CITY OF ALBUQUERQUE

**Re: Funnel Cake Building, 1622 2nd Street NW, Grading and Drainage Plan
Engineer's Stamp dated 9-14-04 (J14-D151)**

Based upon the information provided in your submittal received 9-14-04, the above referenced plan cannot be approved for Building Permit until the following comments are addressed:

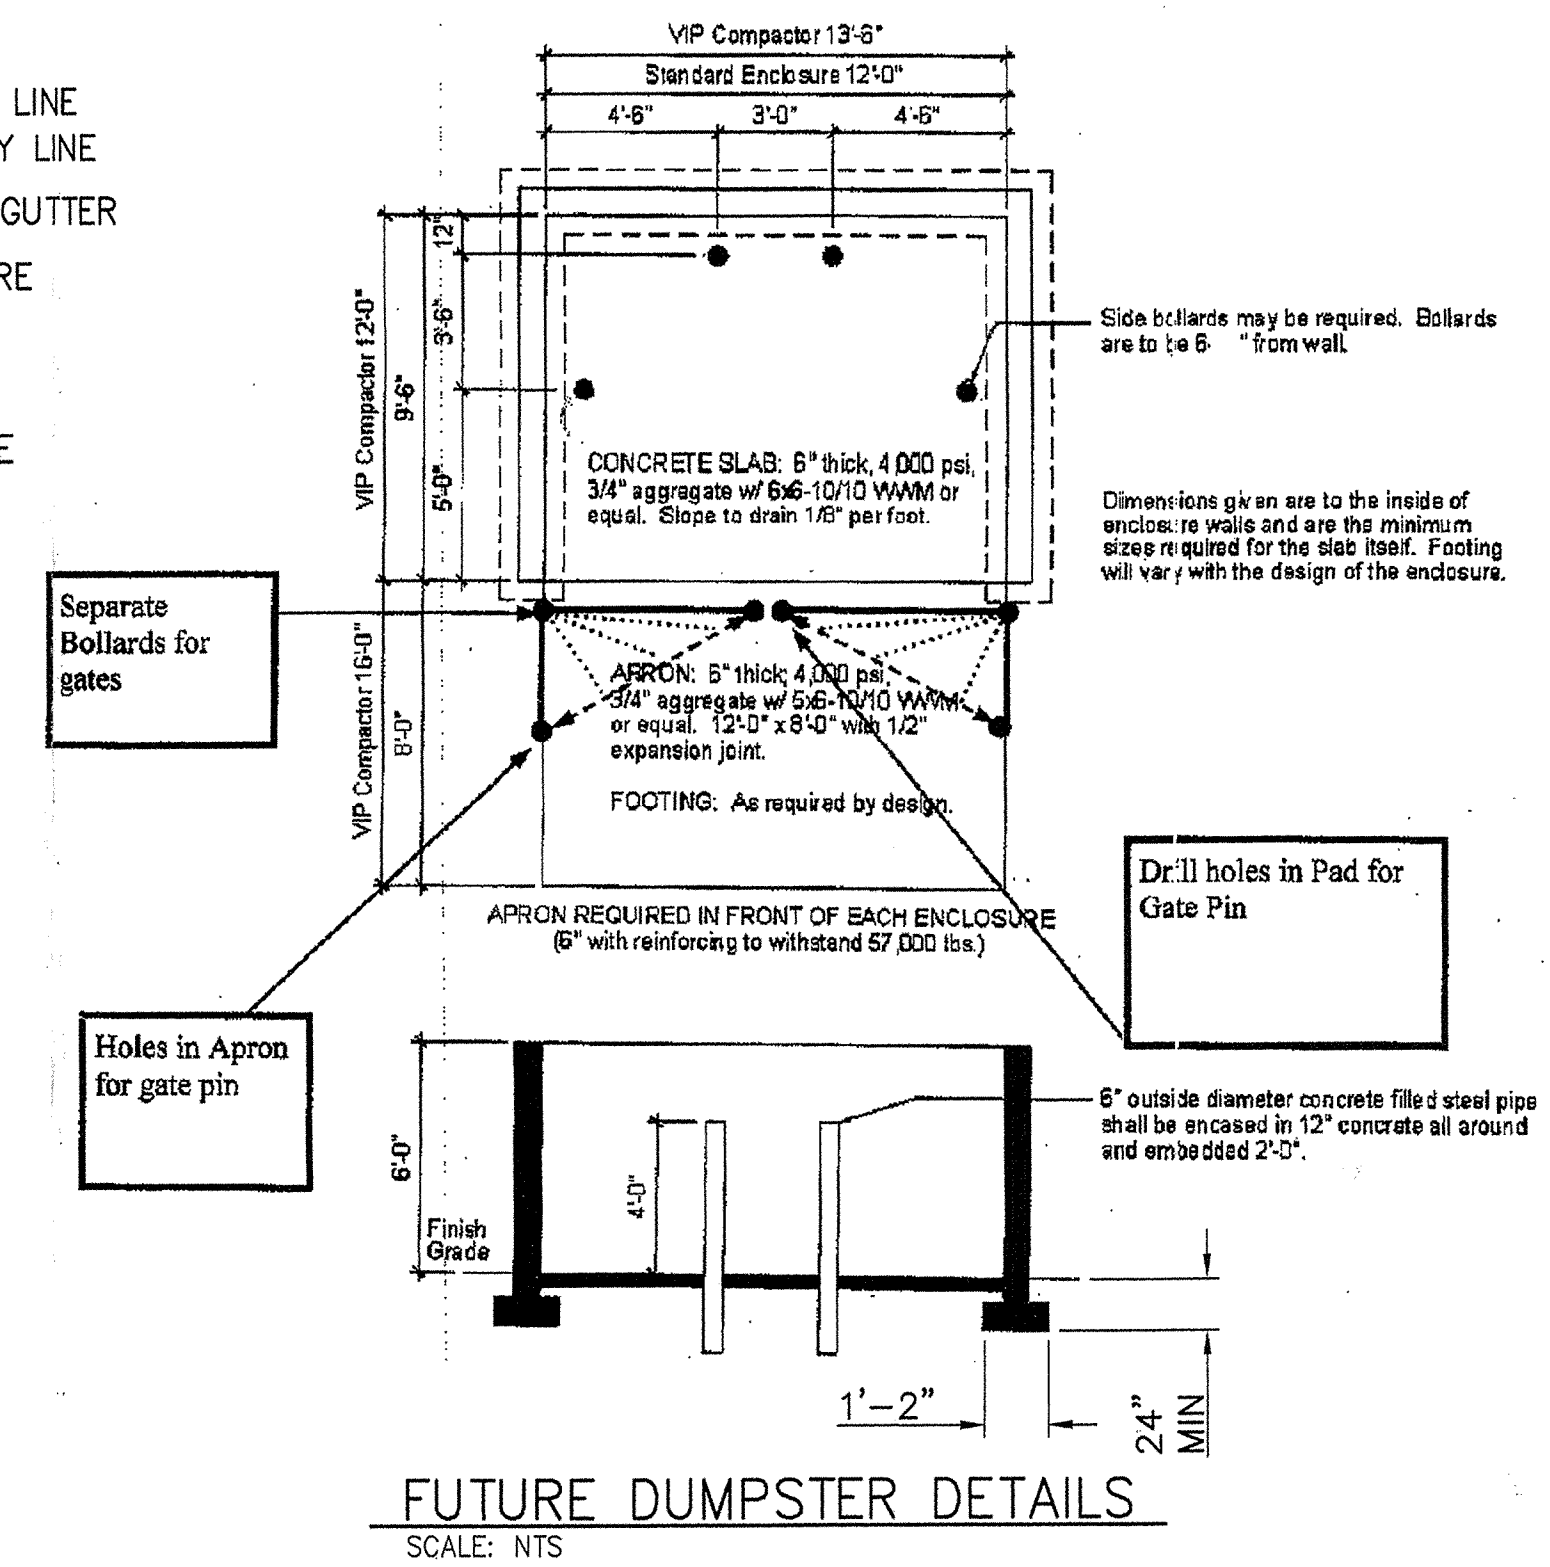
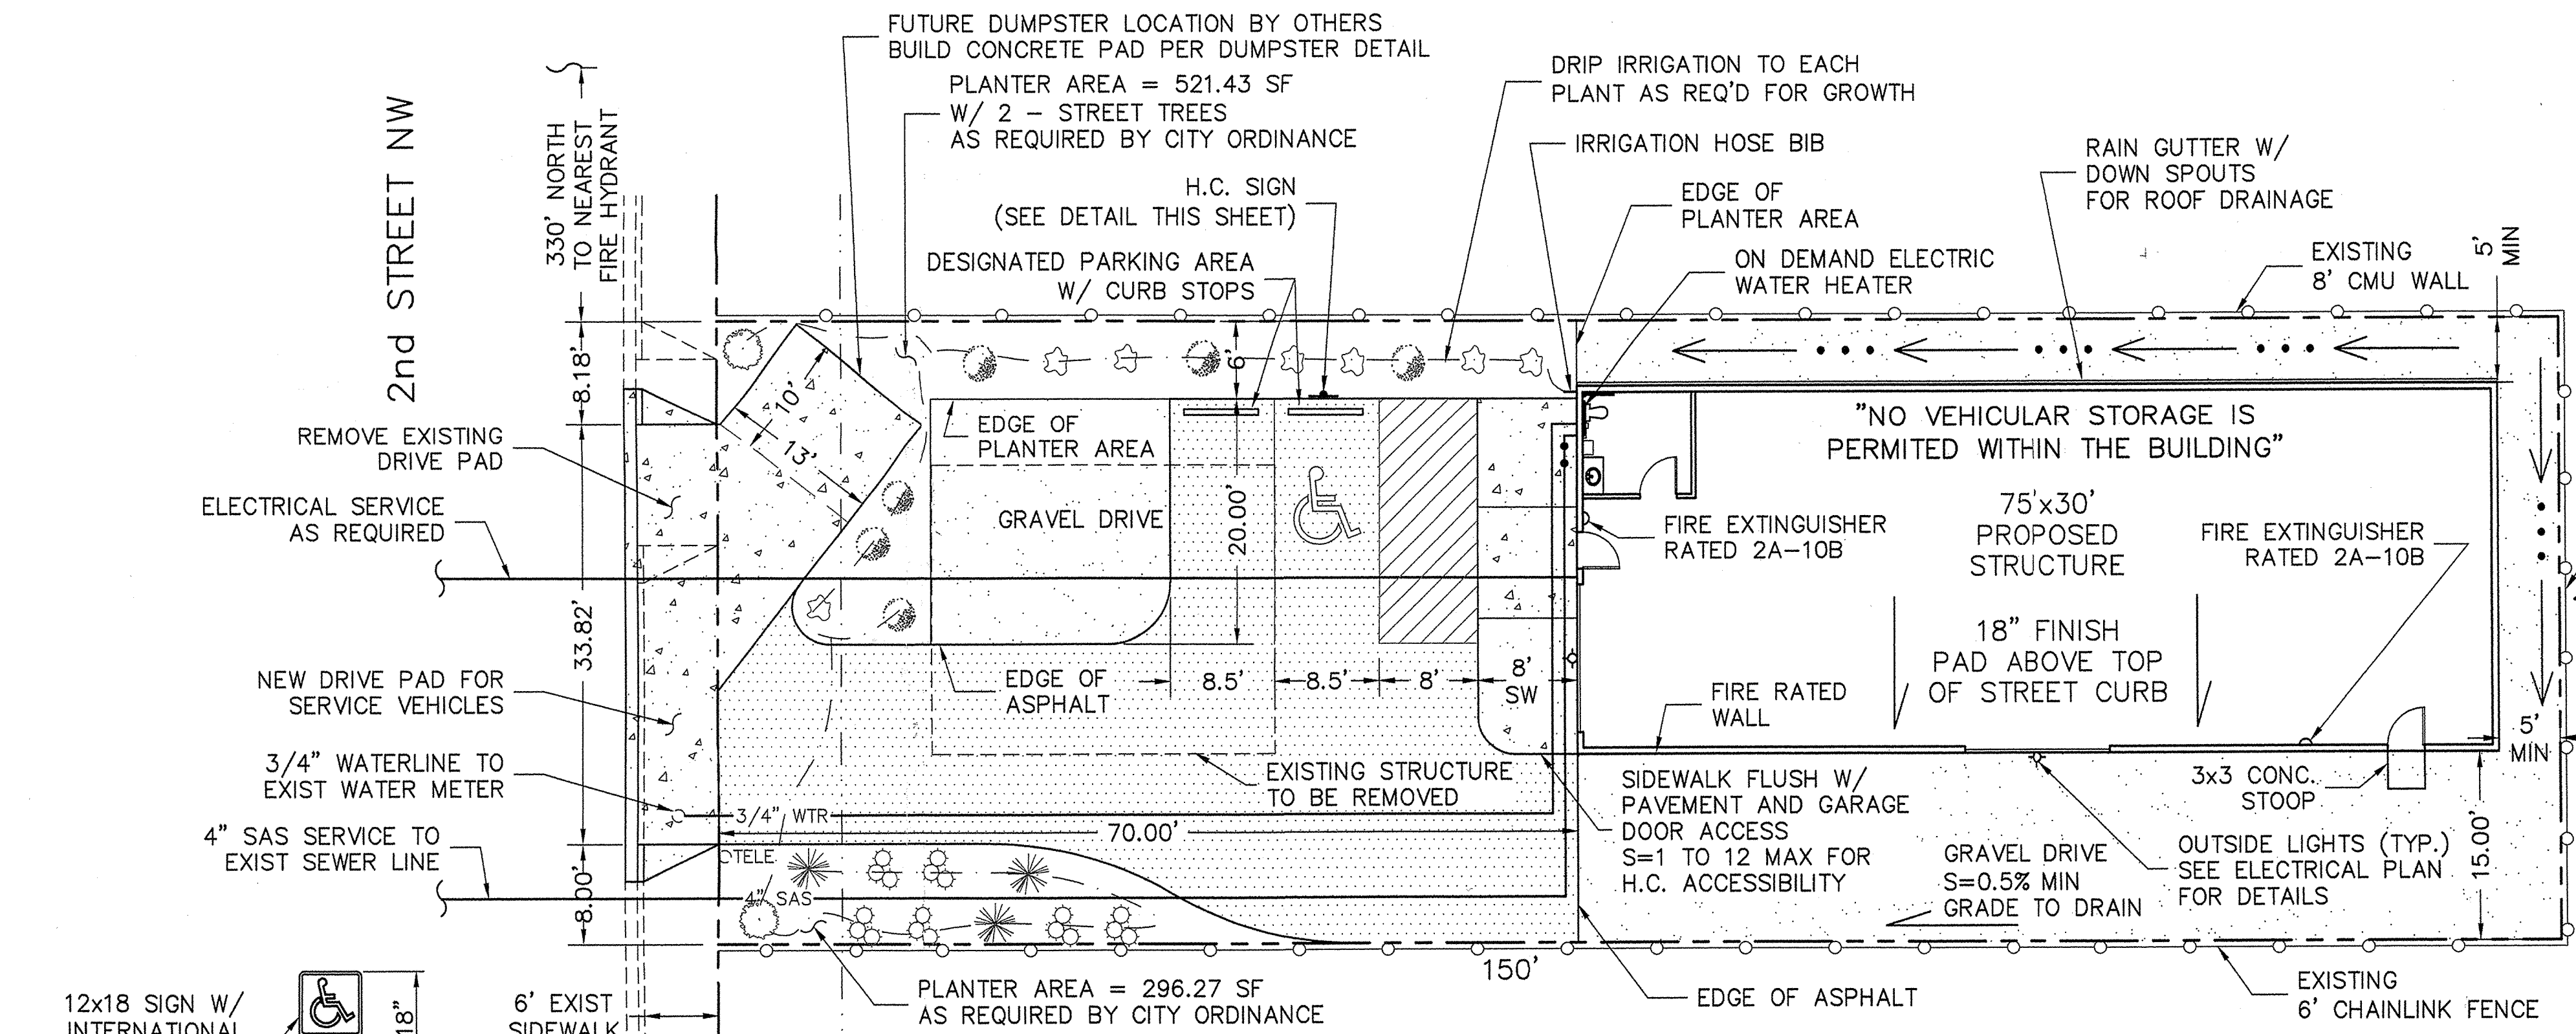
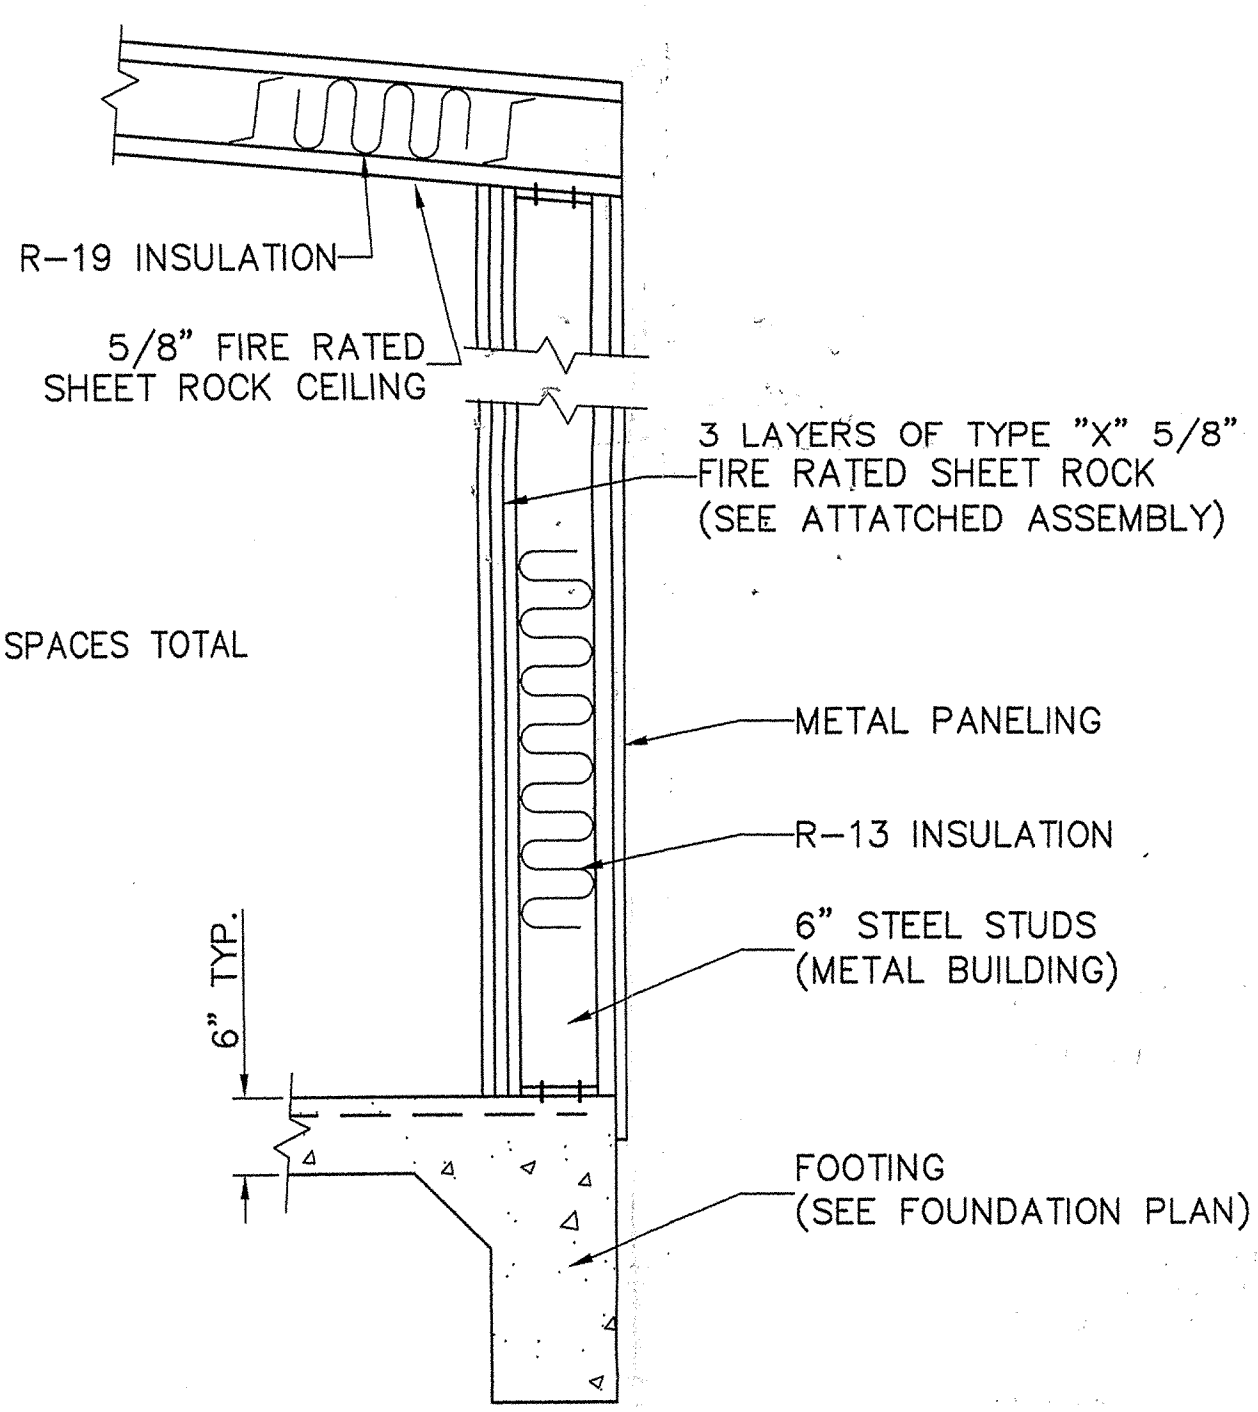
1. The check list shown in Chapter 22, Section 7 of the City of Albuquerque Development Process Manual requires existing and proposed contours to be shown. These contours can be given by contour lines or spot elevations. These elevations must extend a minimum of 25 feet past the site.
2. Address offsite flow.
3. Please provide a swale detail.
4. Define the proximity of the site to any flood hazard zones.
5. Provide a vicinity map.
6. Give both existing and proposed conditions of the site (flow direction, calculated flow vales, etc.).
7. What is the finished floor elevation of the warehouse?
